From: Iain Osenton
Sent: 06 February 2020 11:03
To: Planning
Cc: dcregistration; Linda Griffiths
Subject: 19/02729/DISC - CDC Arboriculture

Regarding the tree pit detail for the above application. Figures A, B and C appear to place the root ball too deep, in line with BS8545 (2014) recommendations.

Title **Tree Pit Detail**

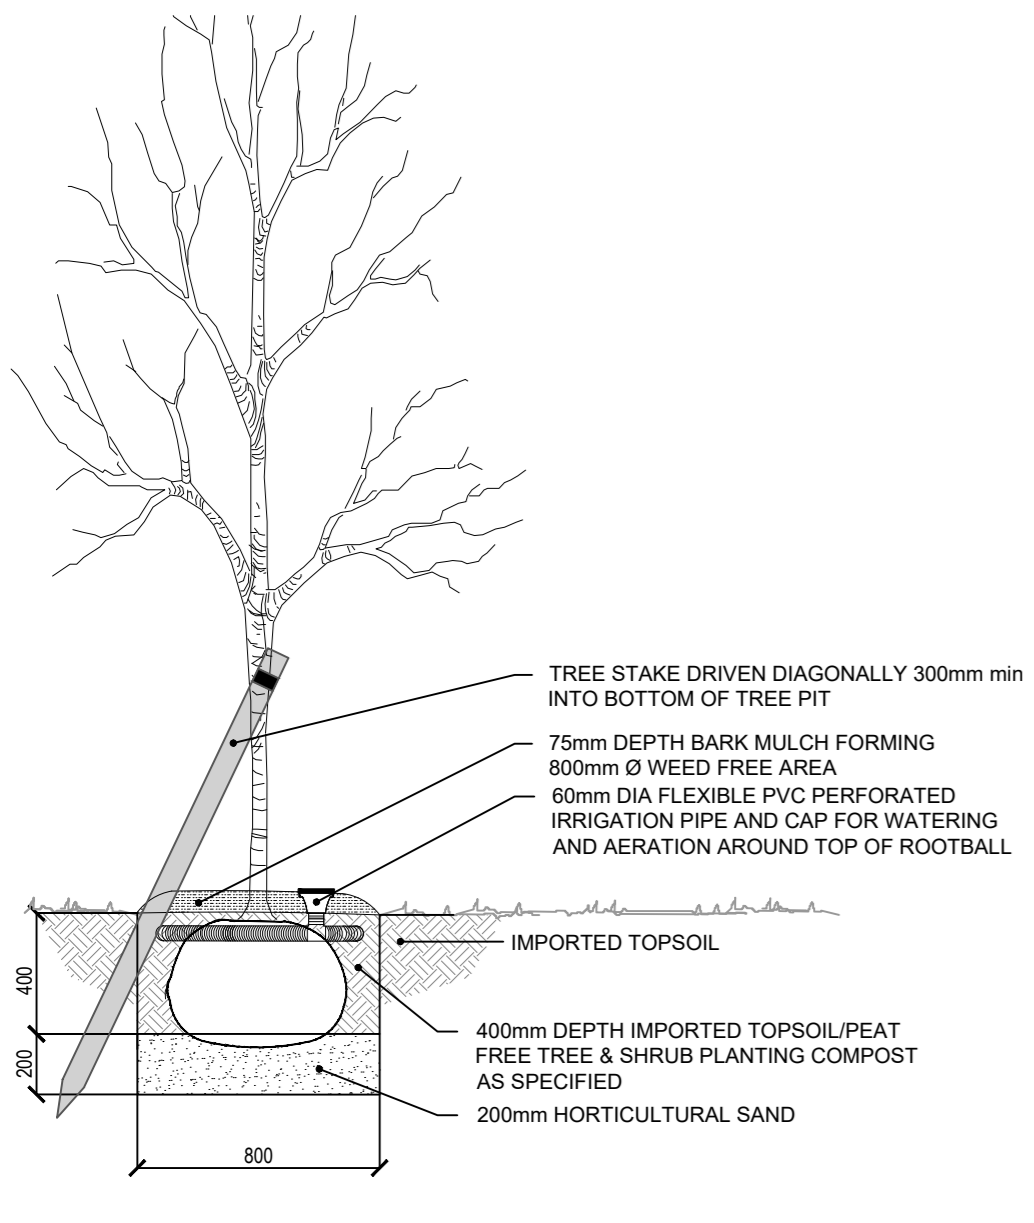
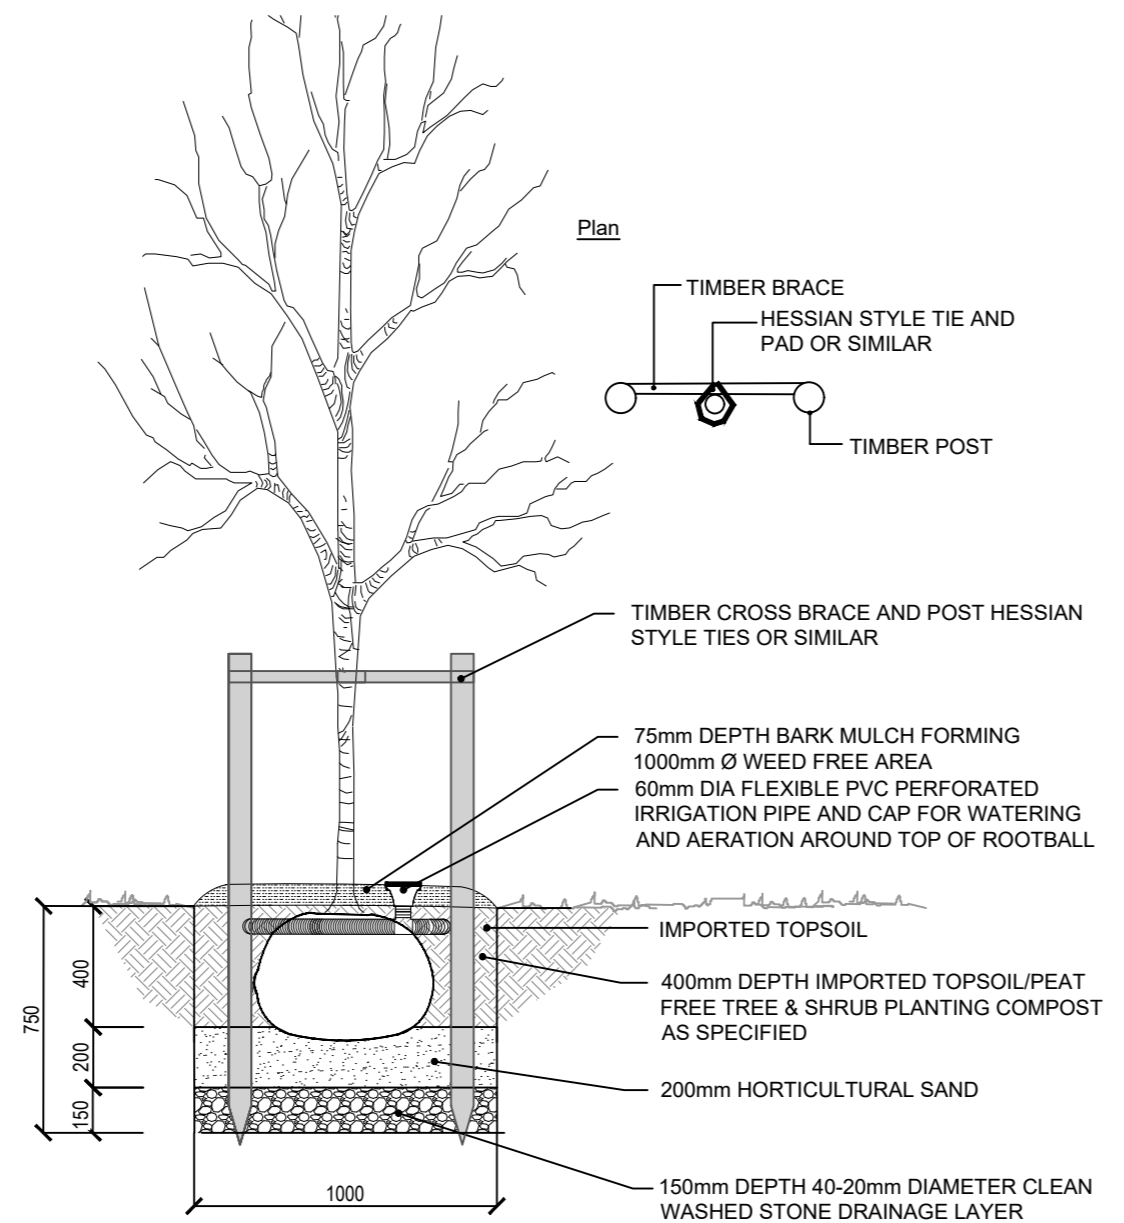
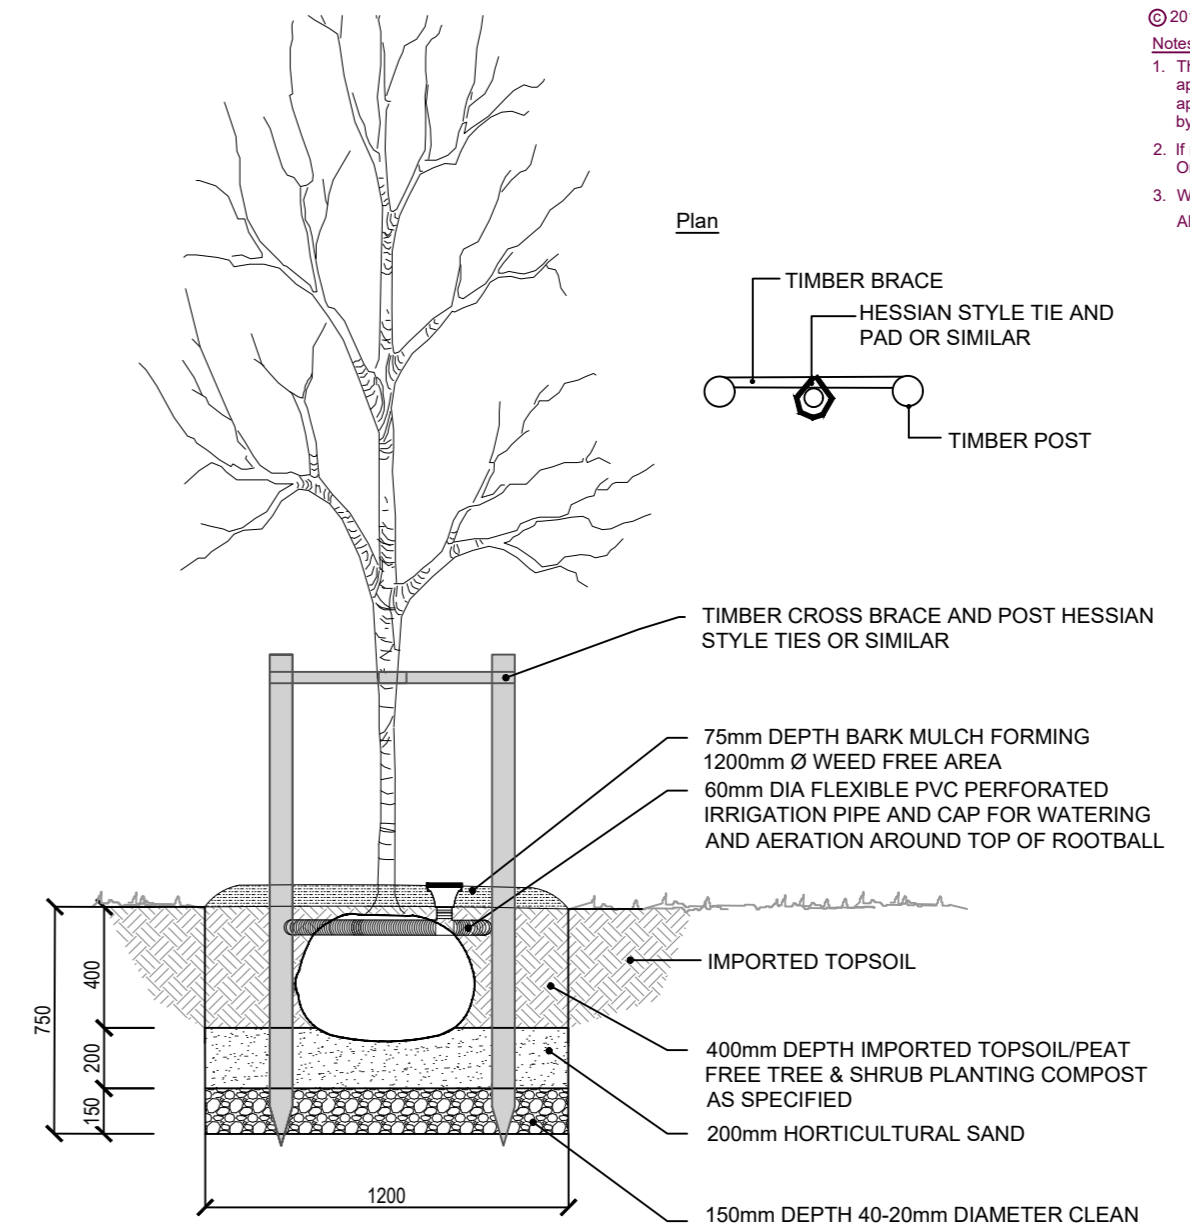
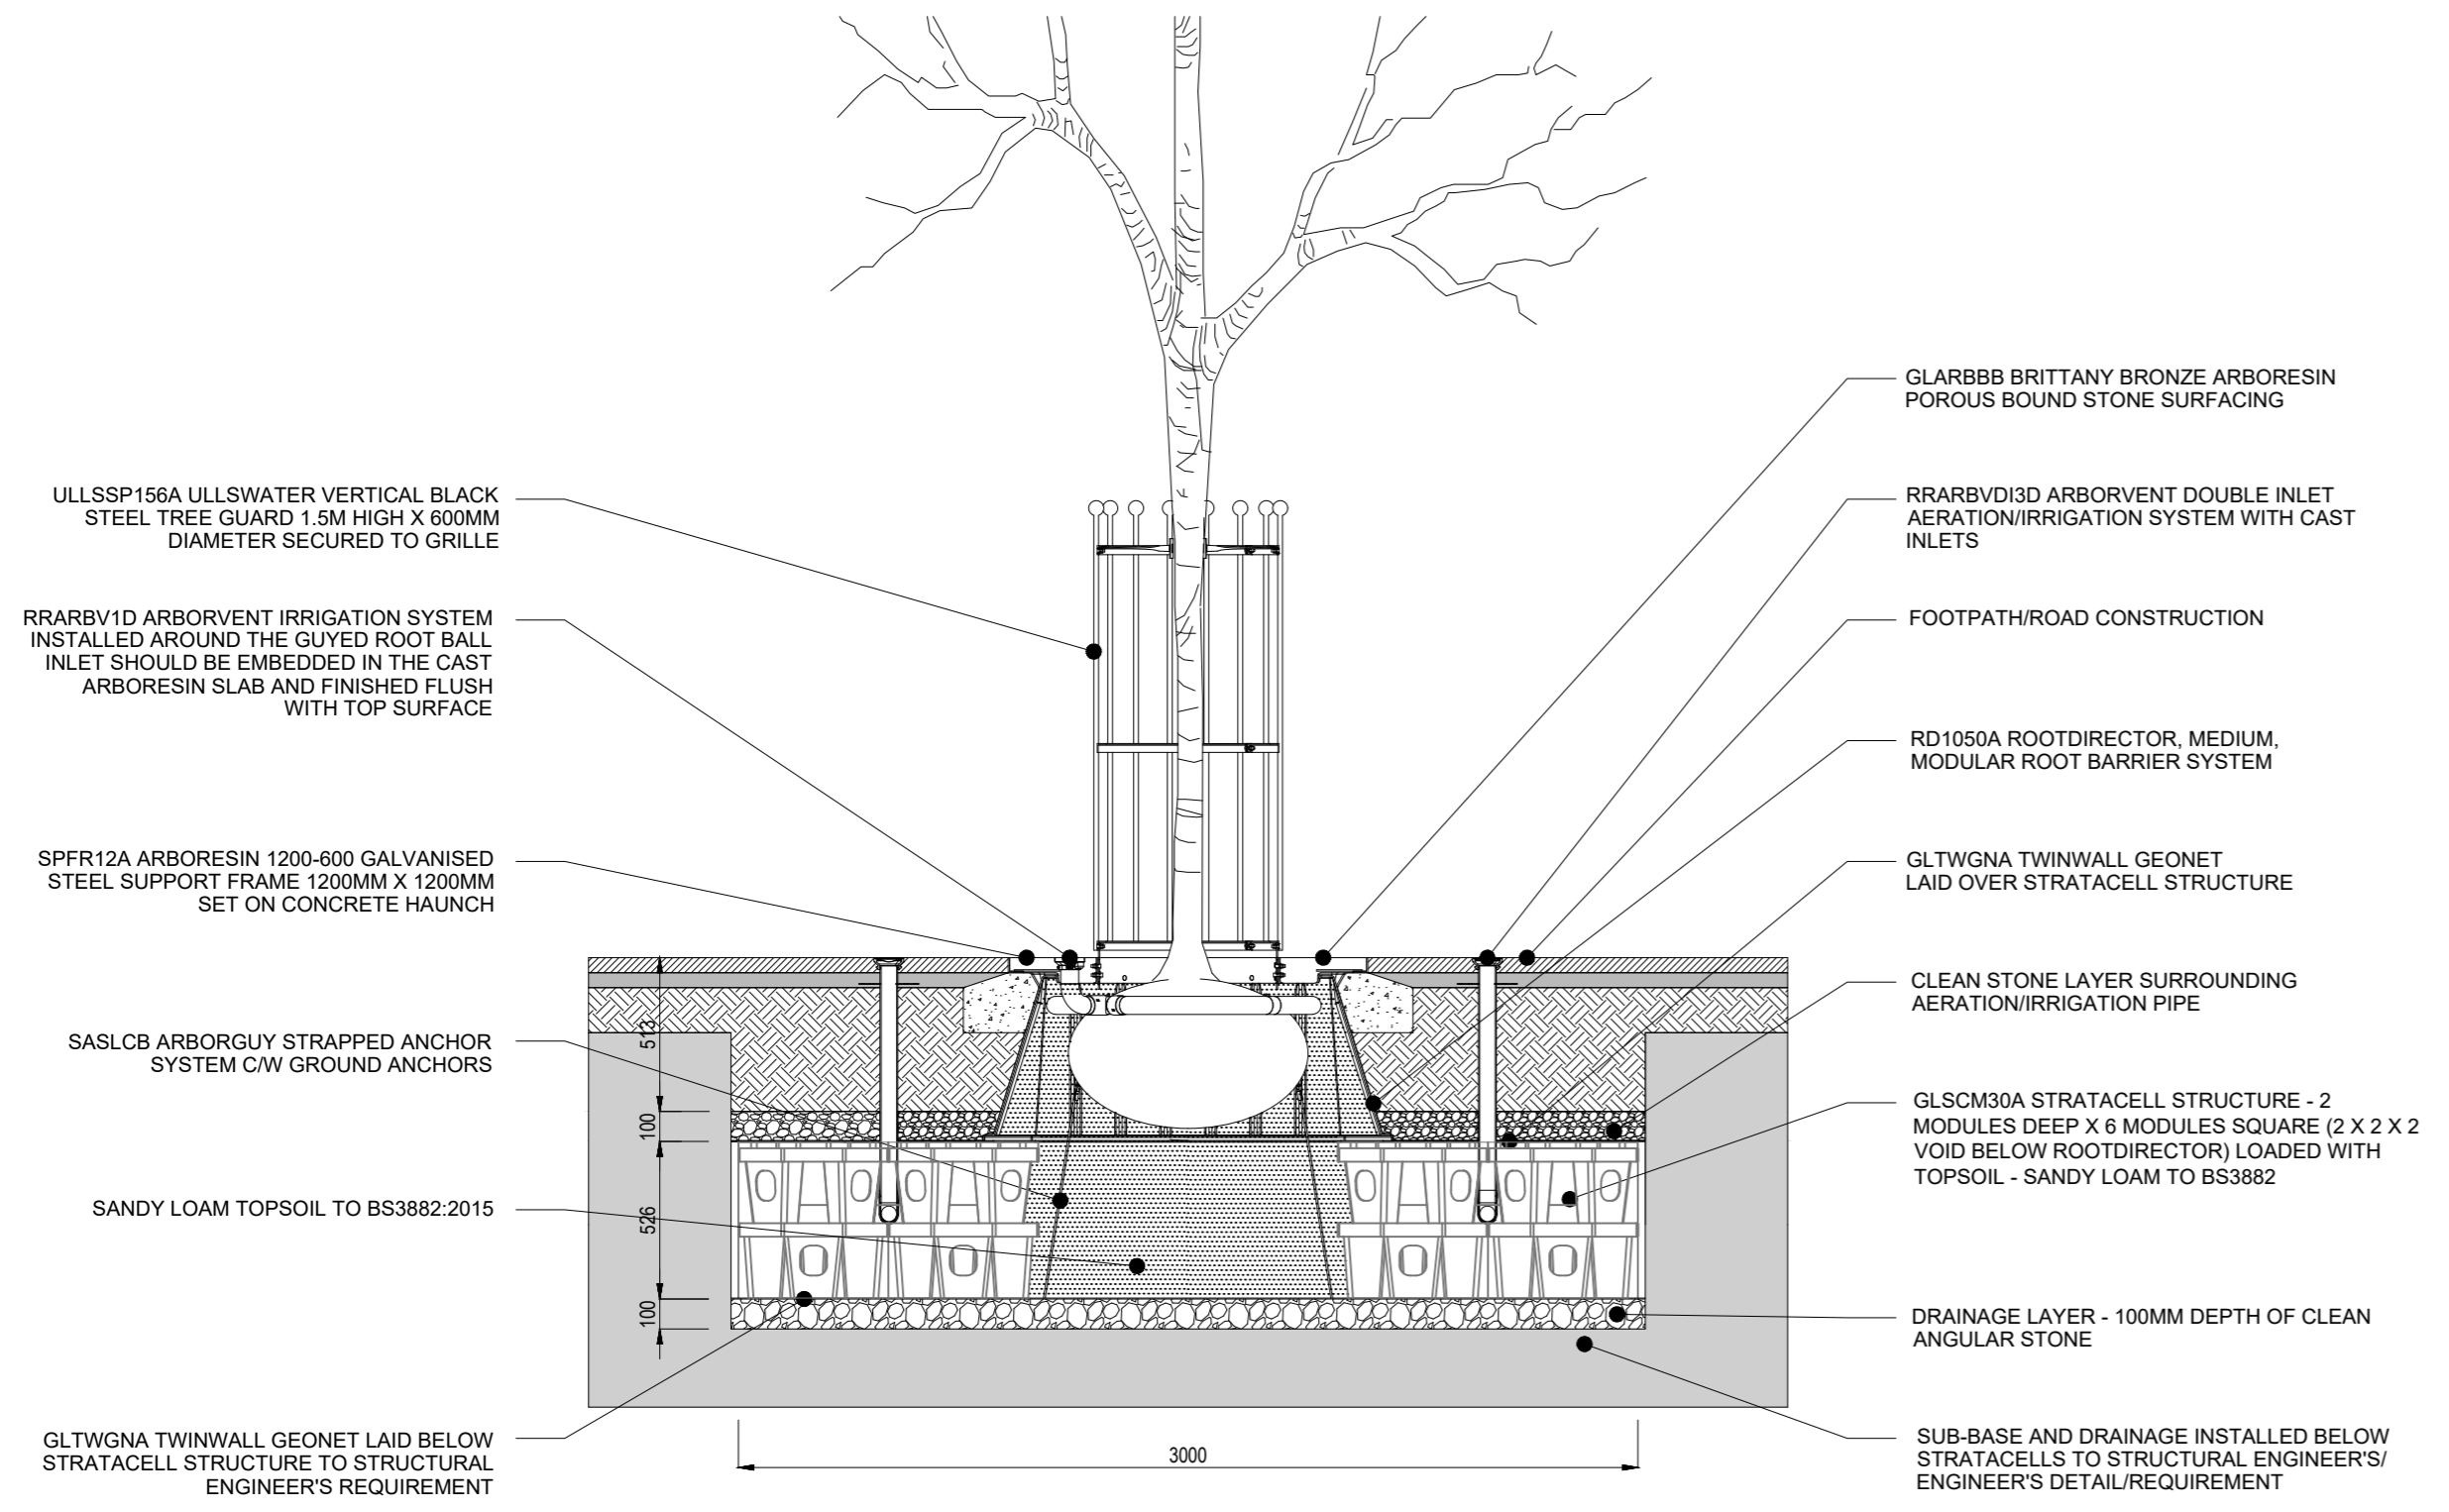
Plans should also be amended so to demonstrate mulch will not be pushed up to the stem of the tree, and also should not cause a bowl effect around the base/flare.
